WEST SUSSEX COUNTY COUNCIL CONSULTATION

TO:	Arun District Council FAO: Simon Davis
FROM:	WSCC - Highways Authority
DATE:	10 December 2021
LOCATION:	Vincent House, 75 Highfield Road, Bognor Regis, PO22 8PD
SUBJECT:	BR/265/21/DOC Approval of details reserved by condition imposed under BR/222/21/PL relating to conditions 4-covered and secure cycle parking spaces, 5-highest available headline speed of broadband & 6-replacement of two bird boxes on building.
DATE OF SITE VISIT:	N/A
RECOMMENDATION:	Advice
S106 CONTRIBUTION TOTAL:	N/A

Vincent House, 75 Highfield Road, Bognor Regis. PO22 8PD
Release of conditions 4,5 & 6 for planning ref: BR/222/21/PL
Drawing no. 1

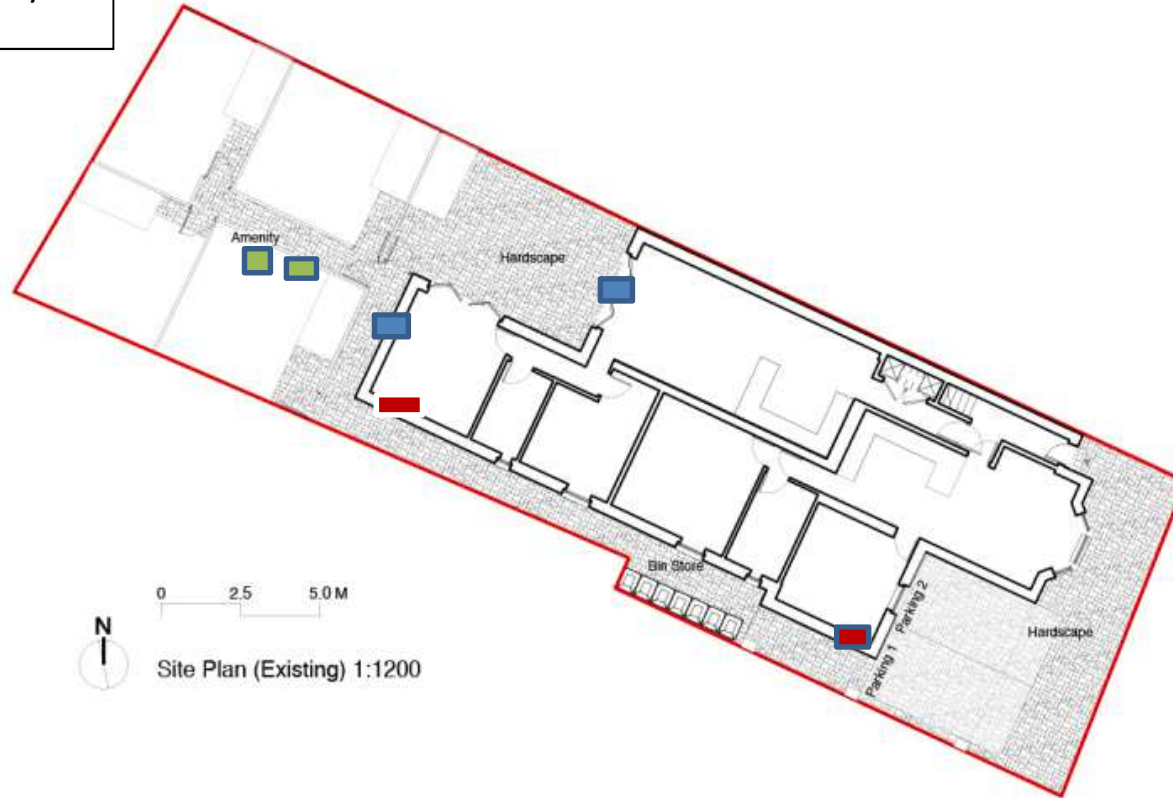
The applicant has submitted a site plan, demonstrating the location of two cycle sheds, providing secure and covered cycle parking provision in accordance with Arun Parking Standards. The LHA is satisfied that Condition 4 can be discharged.
